Subject: App Ref: 2024/90239 - Discharge conditions 4 and 5 (ball-stop netting) on previous permission 2021/93286 for reserved matters application pursuant to outline permission 2020/91215 - Sport England Ref: PA/24/Y/KK/66916

Thank you for consulting Sport England on the additional information in response to Sport England's representation of the 28 May 2024 . The additional information includes documents that details the location and specification of the ball stop netting and its maintenance.

Elevation view;
Cricket Fencing
17m high;75m

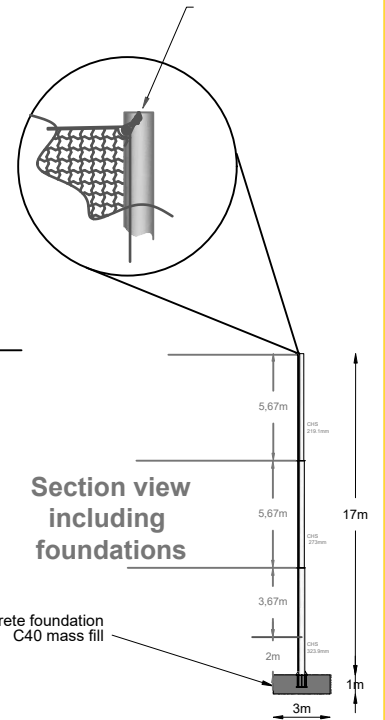
- **Condition 4:**
- *Drawings don't seem to reflect the presence of a 2m timber fence before the netting starts (location of pulleys also to be identified). We are also questioning the position of the fence on the drawings versus the reality of the existing site boundary, the PROW runs across the boundary*

Netting Layout Plan

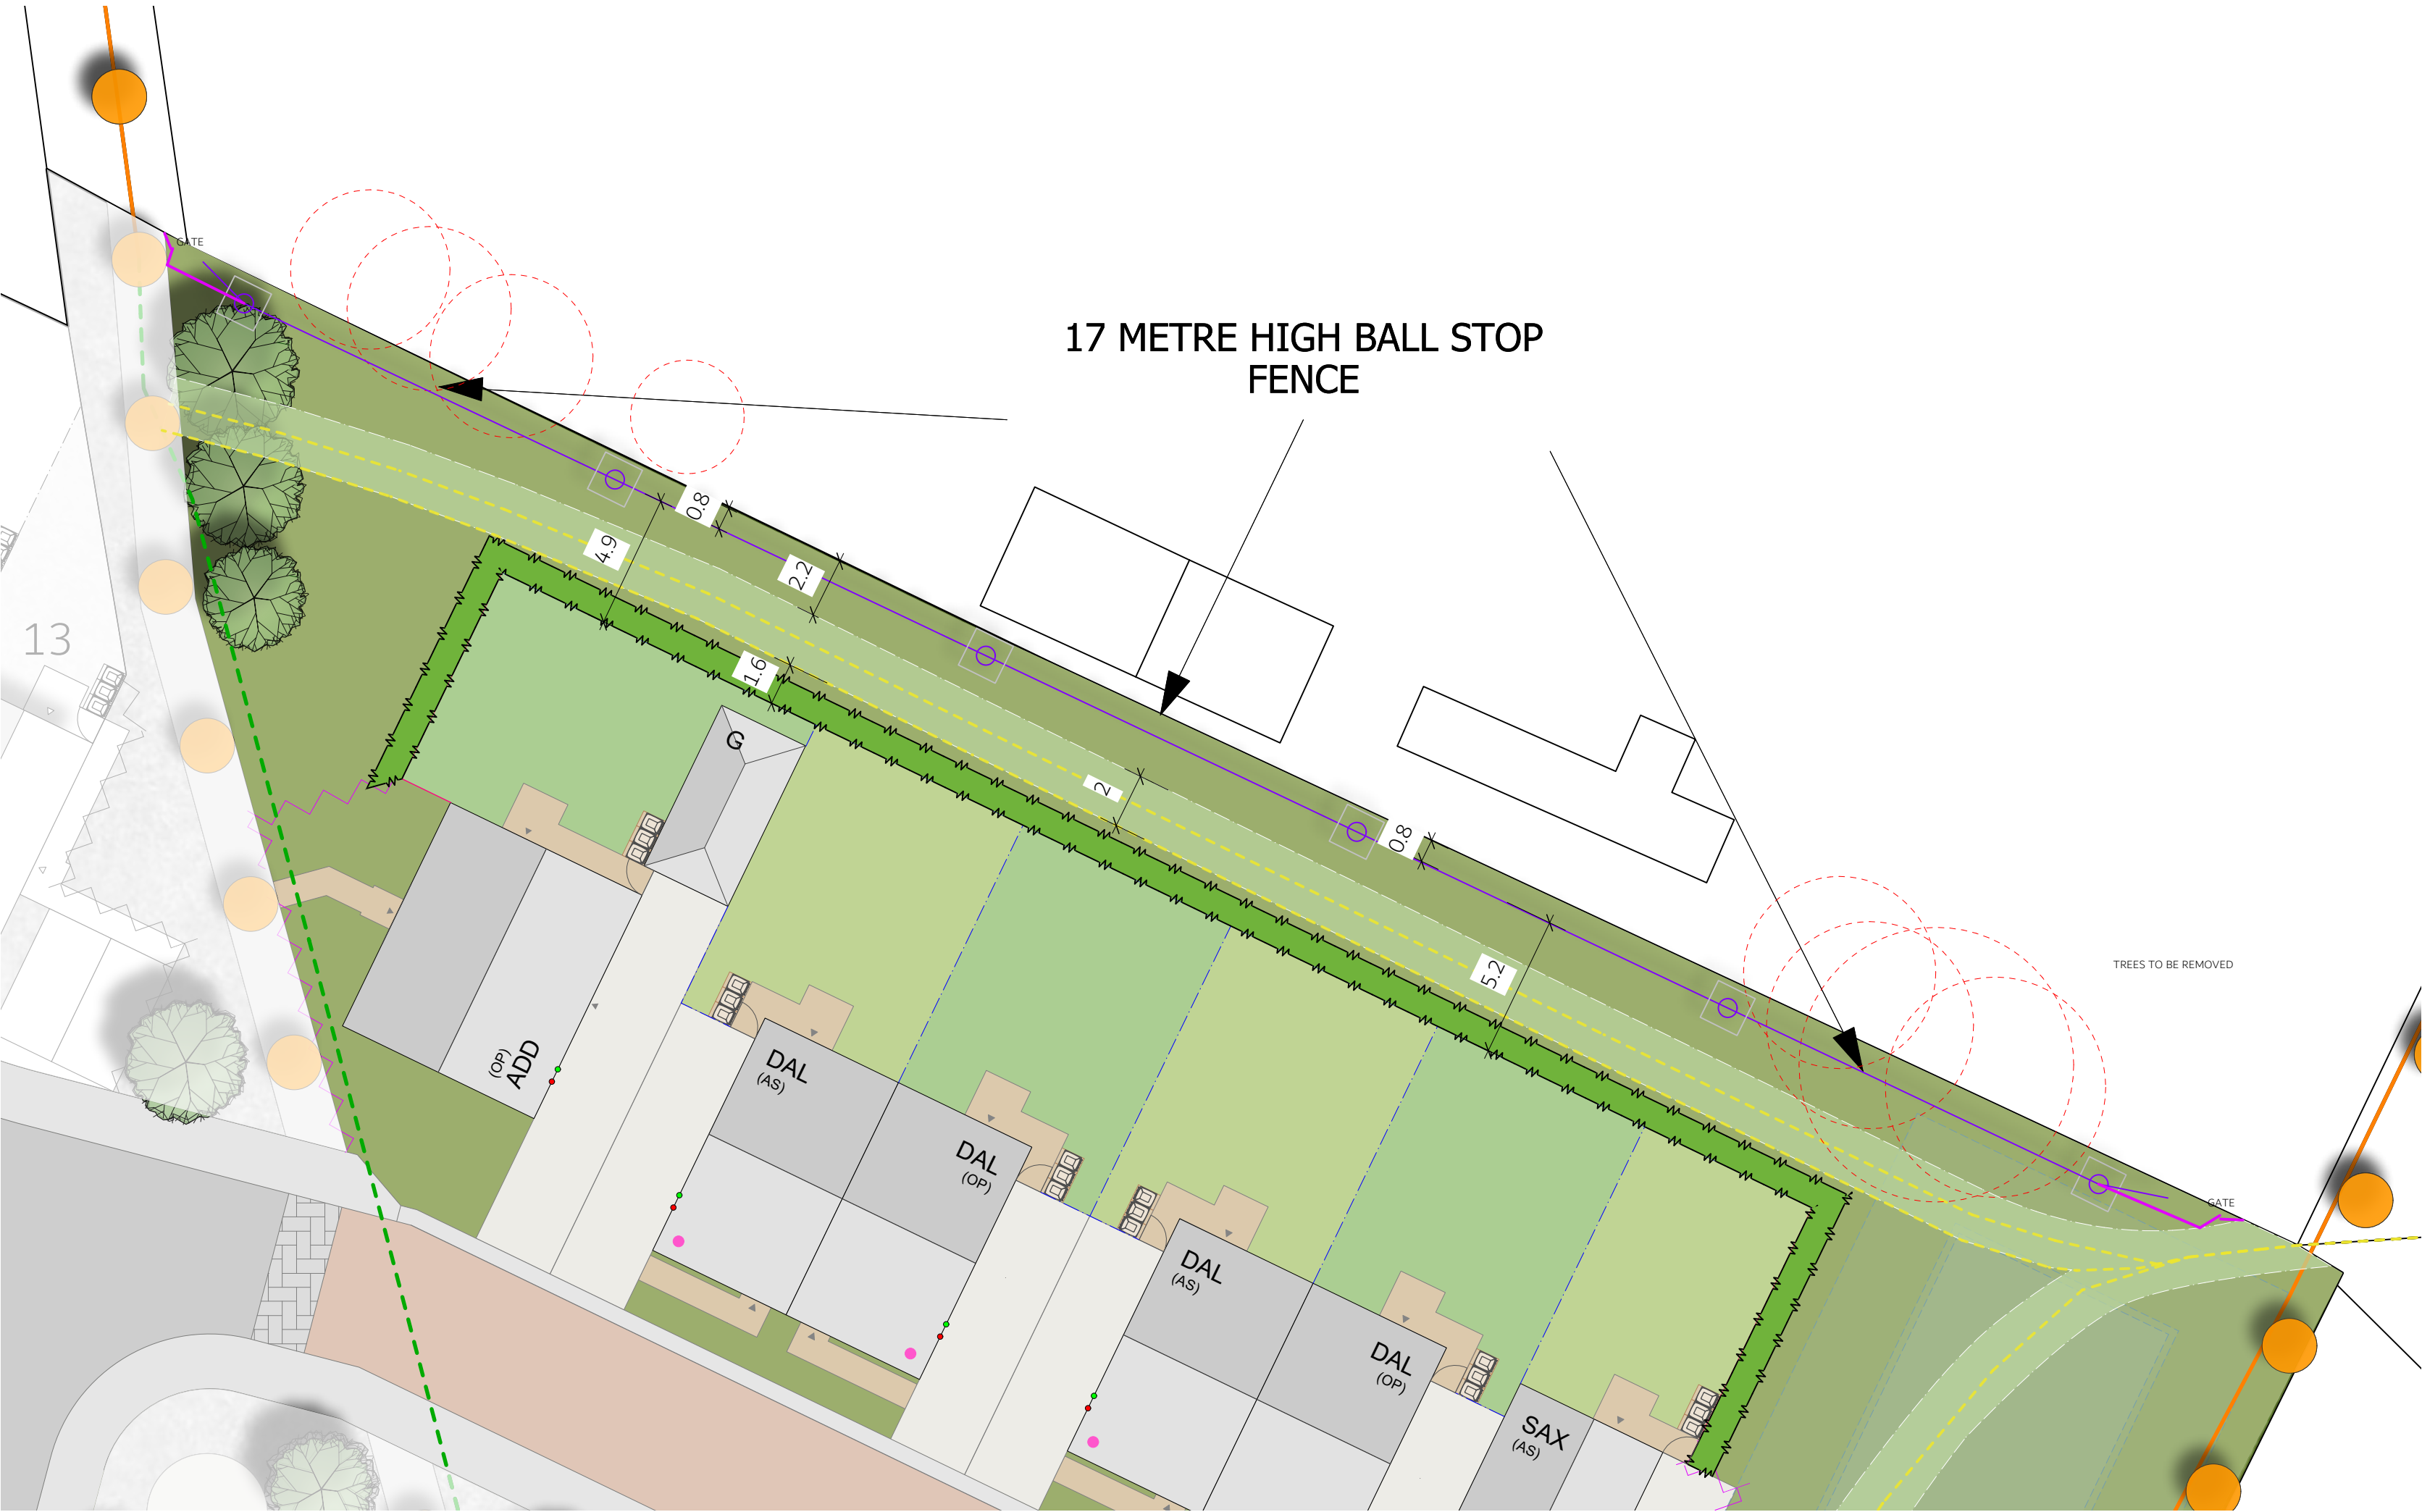
- *The presence of existing trees would interfere with the positioning of the proposed fence. The club are open to a conversation with the developers for the removal of some/all of the trees.*

- *There is currently a boundary wall marking the boundary of the cricket club land. The proposed positioning of the fence would mean the concrete foundations for the fence*

(measuring 3m x 3m x1m) would undermine the current boundary wall. This would make the wall structurally unsafe. The club are open to conversations with the developer as to possible solutions for this.
